Public Consultation  
Submission Report  
– 1st Non-Statutory  
Public Consultation

# BusConnects Dublin Core Bus Corridor Projects

## Corridor 1 – Clongriffin to City Centre

### Emerging Preferred Route – Public Consultation Report 2018/2019

CLONGRIFFIN TO CITY CENTRE CORE BUS CORRIDOR SCHEME  
JUNCTION SYSTEMS DESIGN  
MARINO AVENUE BRIAN ROAD MALAHIDE ROAD

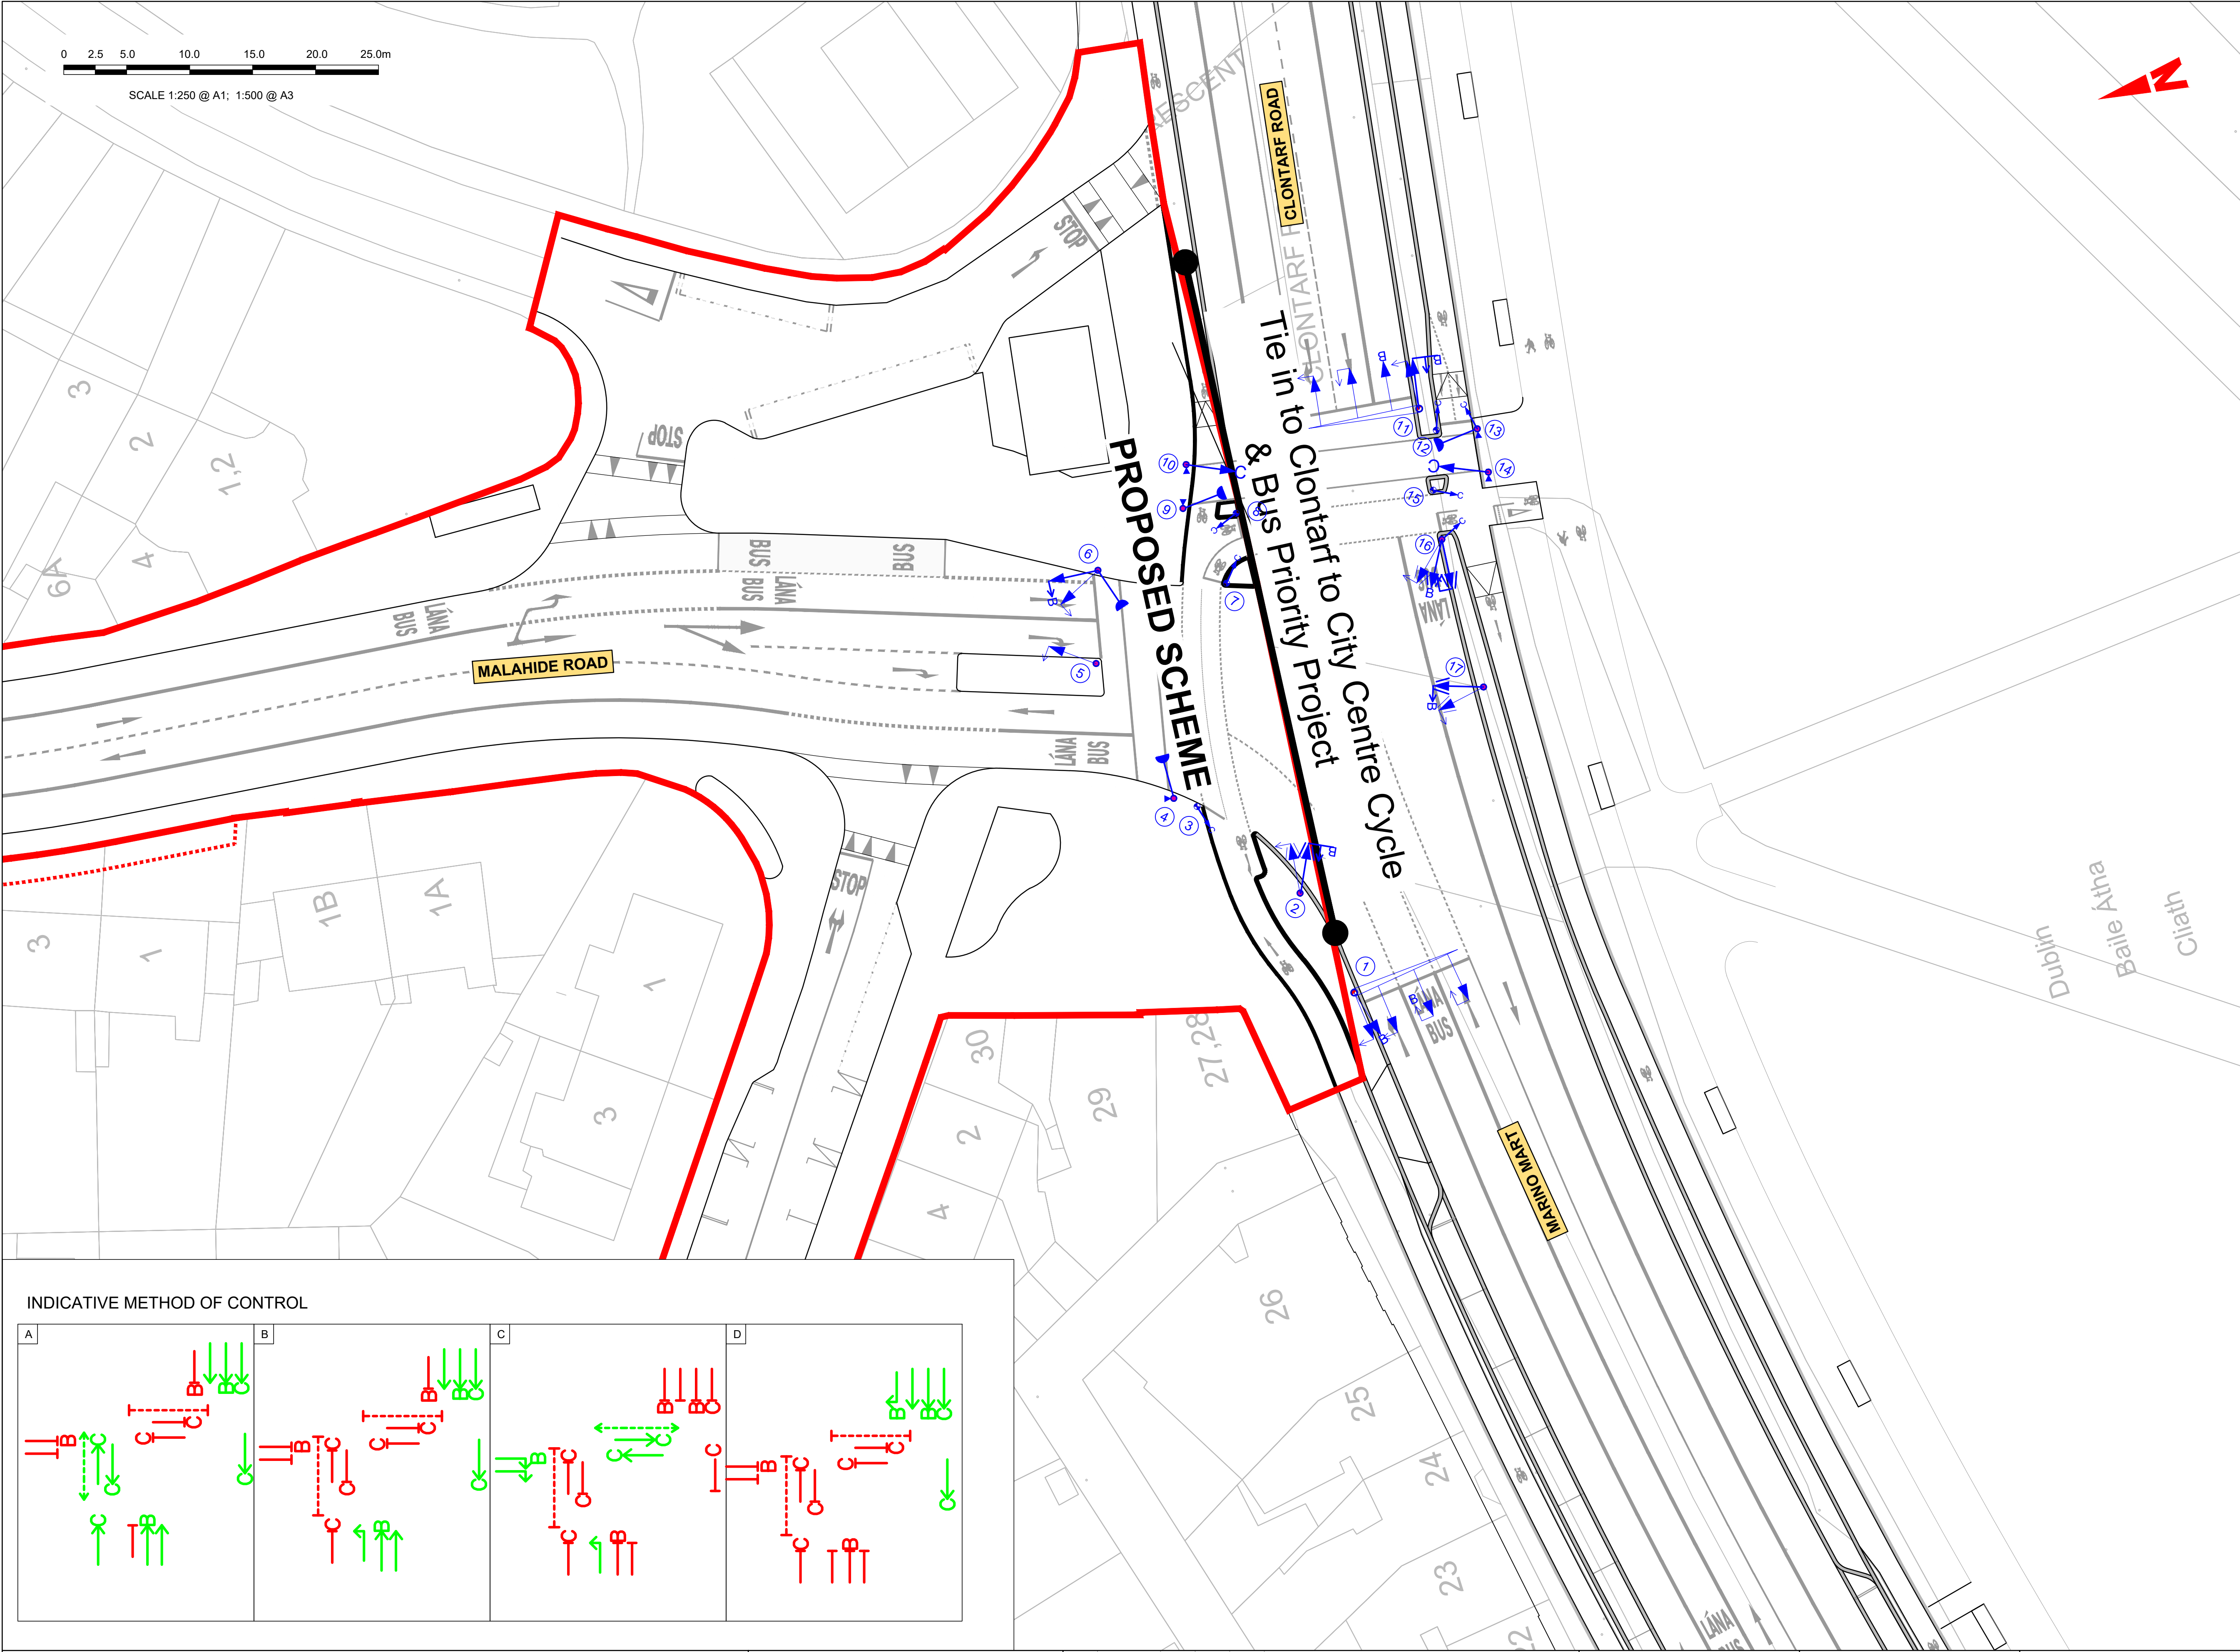
The Marino Cyclist Diversion imposes huge safety risks for cyclists. An inbound cyclist is required to cross 4 lanes of traffic from Malahide Road onto Brian Road and from Haverty Road to join the City Centre cycle scheme. They are also required to dismount upon crossing at Brian Road, at a toucan crossing. Other junctions have cyclists between two lanes of traffic which is unsafe. The redirection of cyclists onto routes that are used as a rat run will also pose a danger to cyclists, particularly at peak times.

The designs at this stage of planning are preliminary in nature, and will require significant additional work to bring them to a point where the NTA is prepared to submit the overall proposal for planning consent. The various issues raised in this consultation process will also feed into the designs.
